Arun District Council
Civic Centre
Maltravers Road
Littlehampton
West Sussex BN17 5LF

Application for Planning Permission

Development: Removal of tennis court and construction of 1 No self-build single storey energy efficient dwelling. This application is a Departure from the Development Plan, may affect the setting of listed buildings, affects the character and appearance of the Church Lan, Yapton Conservation Area and is in CIL Zone 3 and is CIL Liable as a new dwelling.

Location: Church Farm House Church Road Yapton BN18 0EP

Drawing Title:
Existing Plan

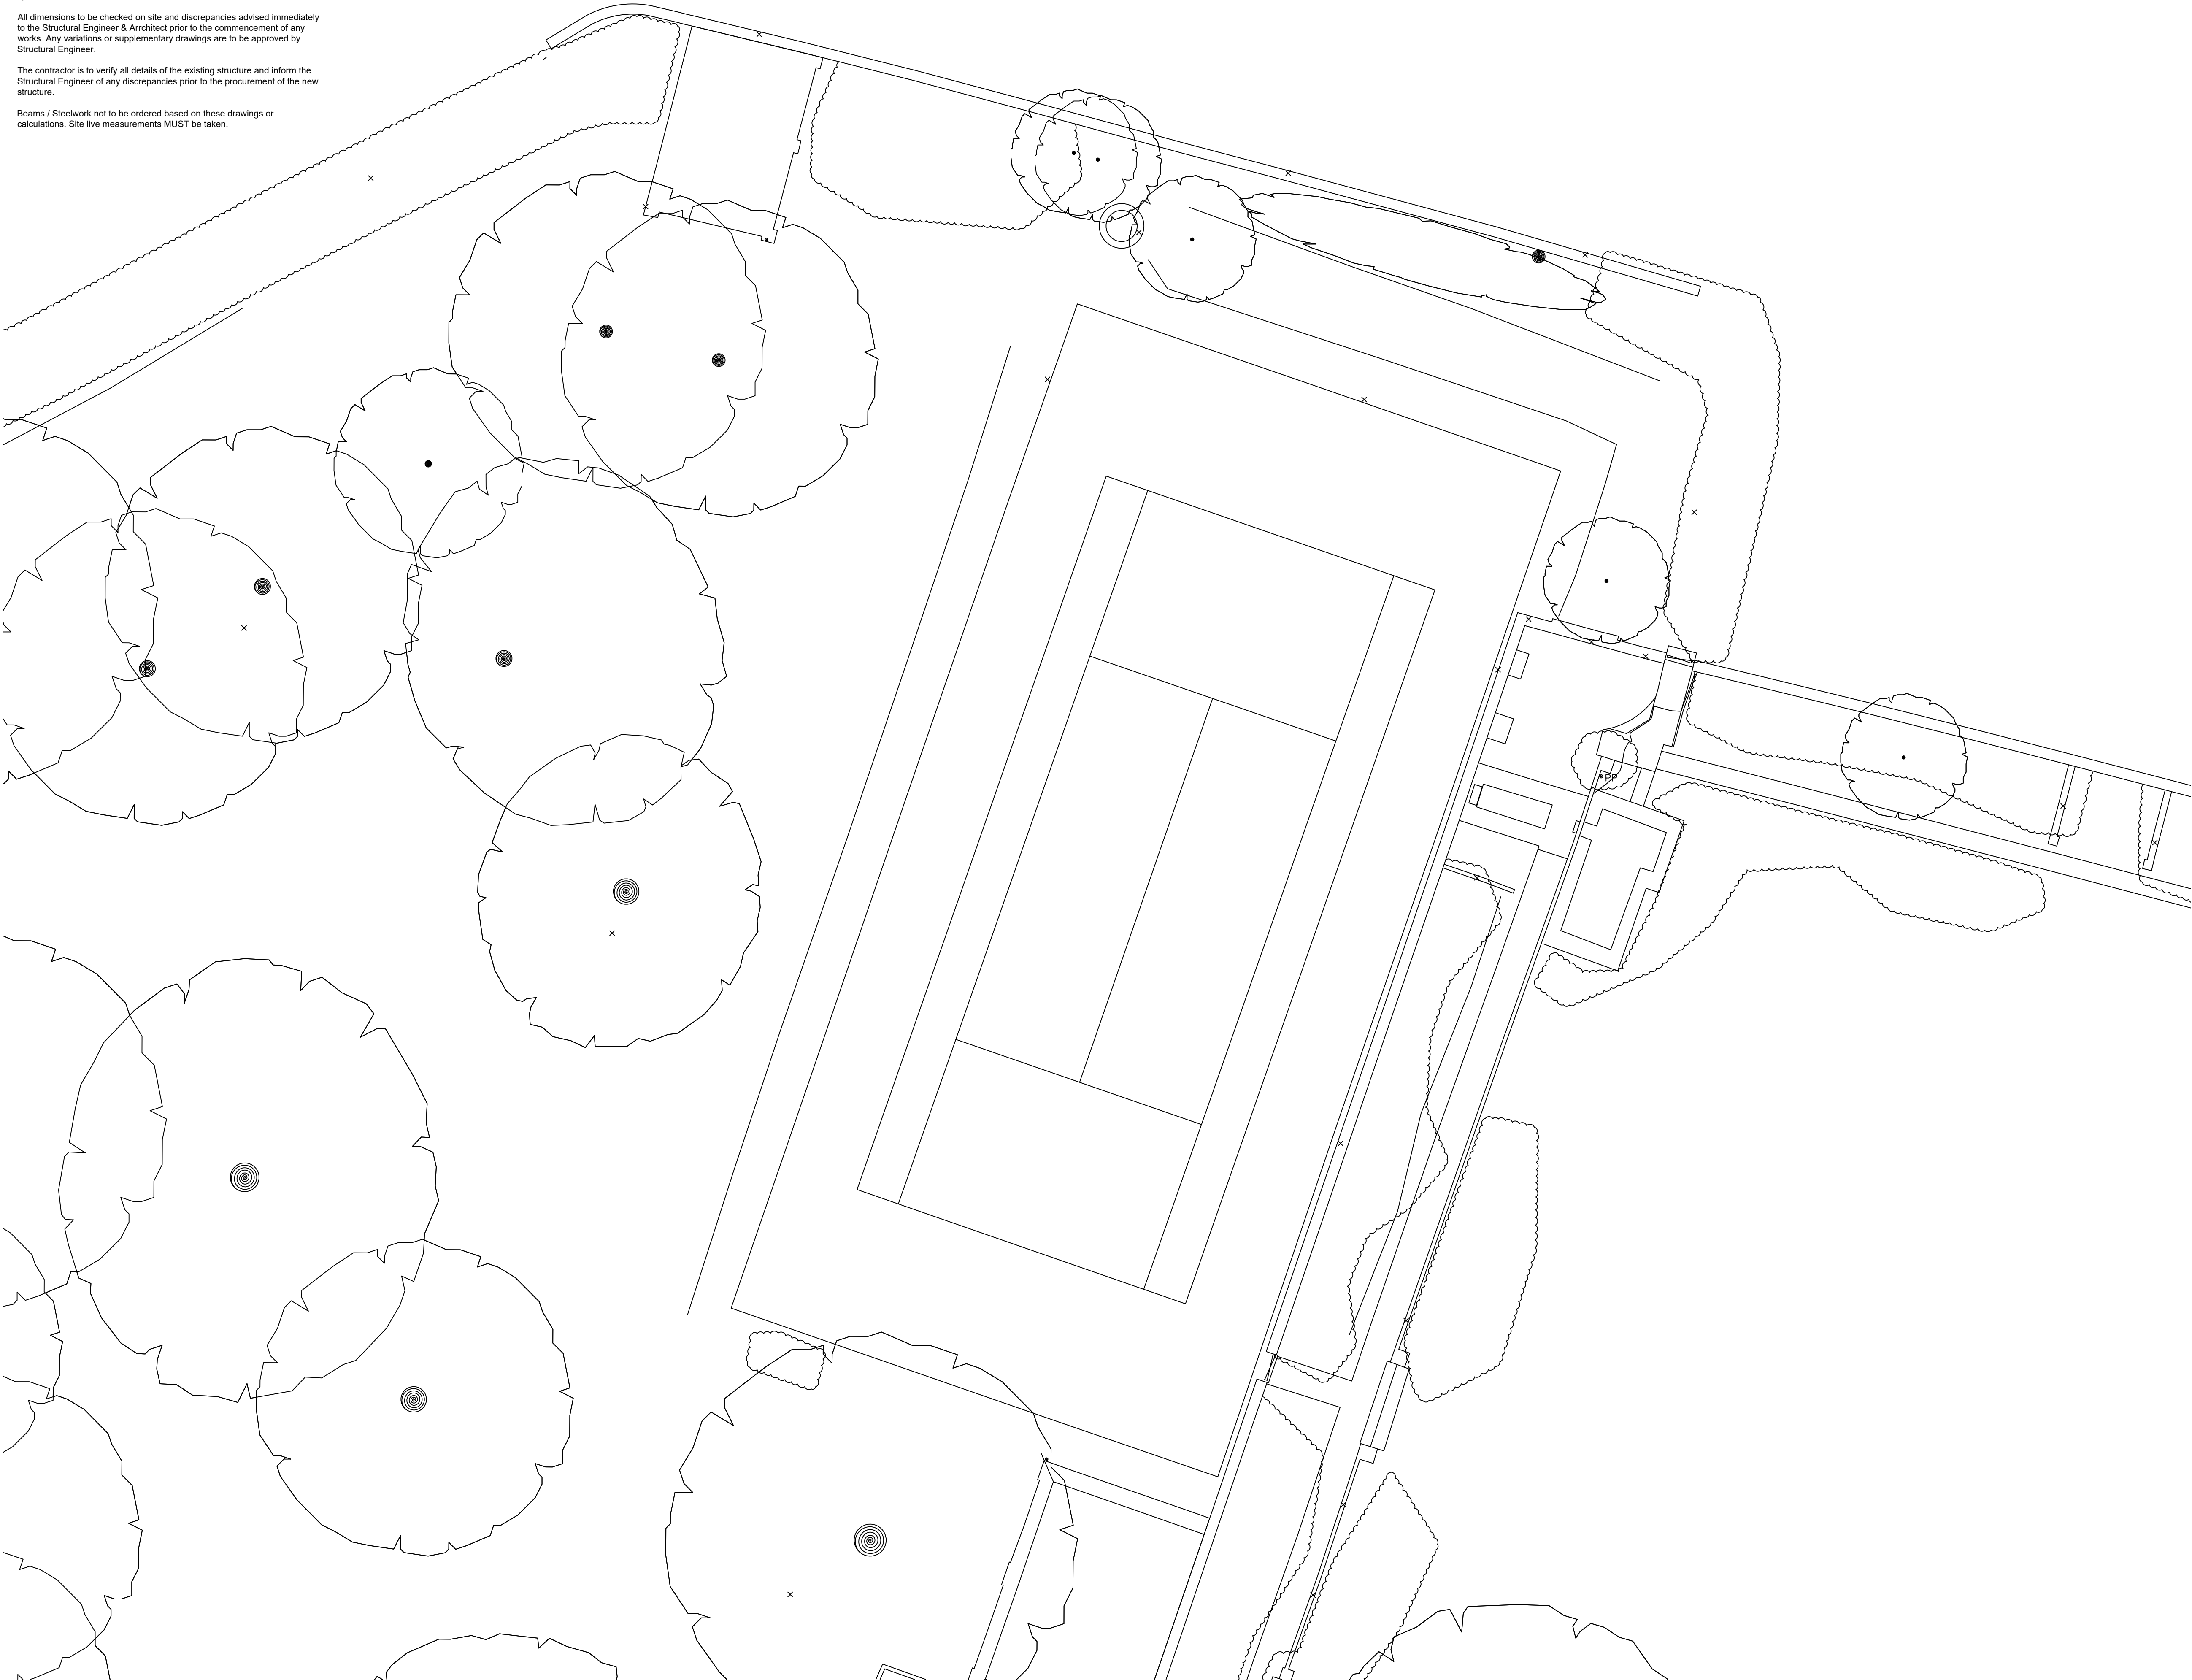
On the existing site plan, please provide a North point.
